**Application Number SSI 7485****WestConnex M4-M5 Link – Modification 2 The Crescent overpass****Lydia Jebakumar**

Figure 4-1 Overview of the proposed modification

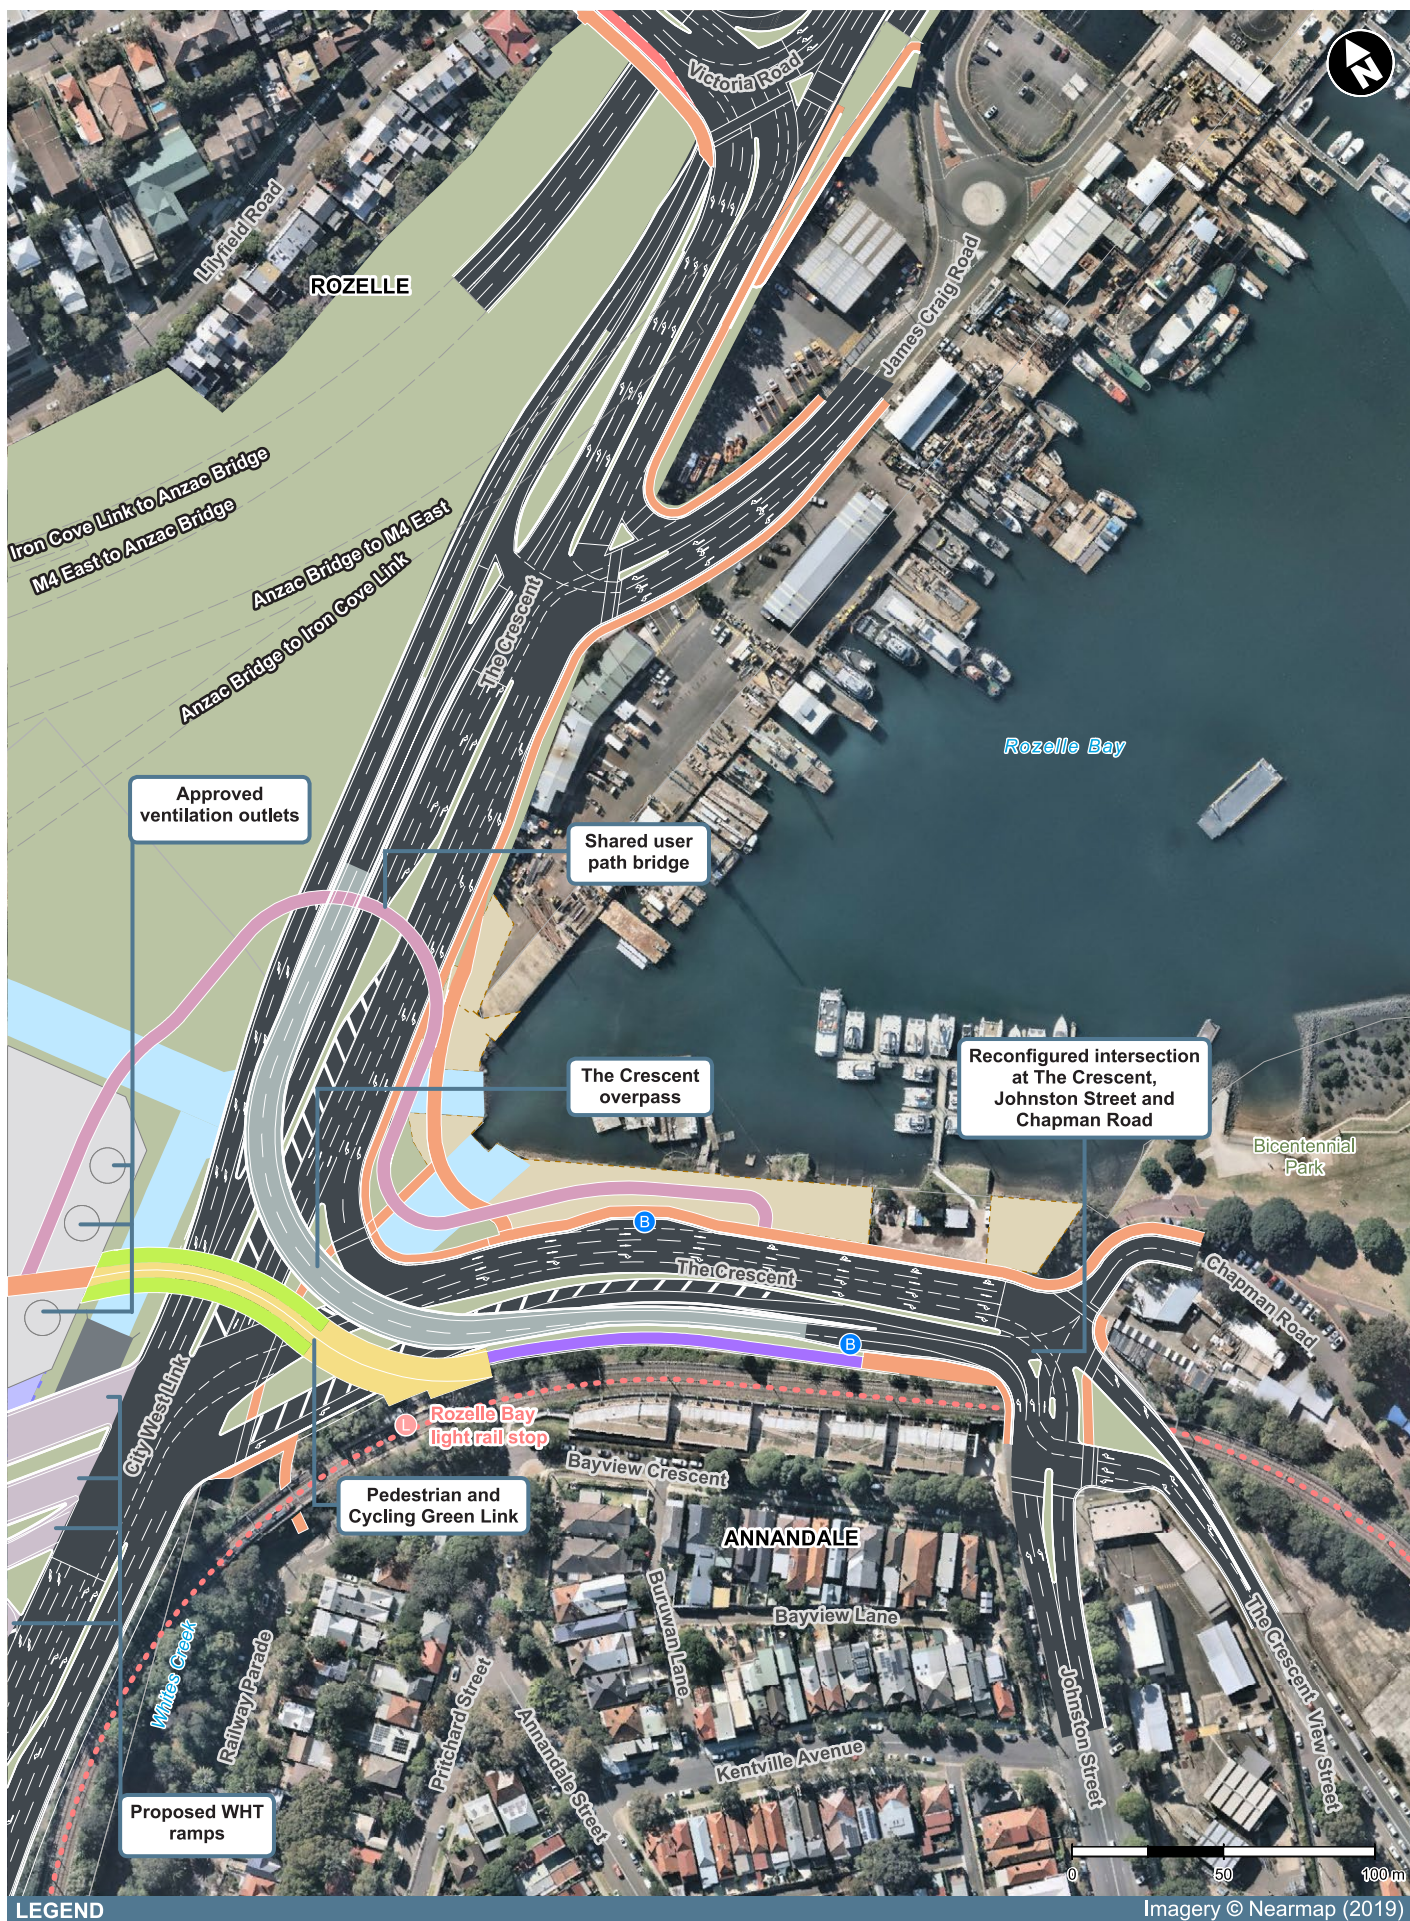
I am concerned about the changes in the design, especially regarding loss of the direct, connected shared user pathway from the Crescent/Whites Creek path to Glebe Foreshore. Access to the Glebe Foreshore provides access to quality green space for local residents, as well as a key link to destinations such as schools like Blackwattle and the city, for children and slower cyclists who prefer a quieter, flatter and more scenic route.

Relocating the green link to the west so that it will no longer directly connect with the Glebe foreshore and installing multiple traffic lights to cross would compromise access for pedestrians, cyclists and wheelchair users, adding to commute times and reducing safety. This seems inconsistent with the recently announced Premier's priority to ensure all Sydney residents are within 10 minute walking distance of quality green space - especially if it takes close to that time to cross the road.

If the reroute adds distance as well as elevation, it could present significant challenges for less mobile/less fit community members to access the parks and connection to the Fish Markets/Sydney city - including for prams and wheelchairs.

Please rethink flat, direct shared use access to the Foreshore, especially since this was what was previously approved as a condition for removing Buruwan Park.
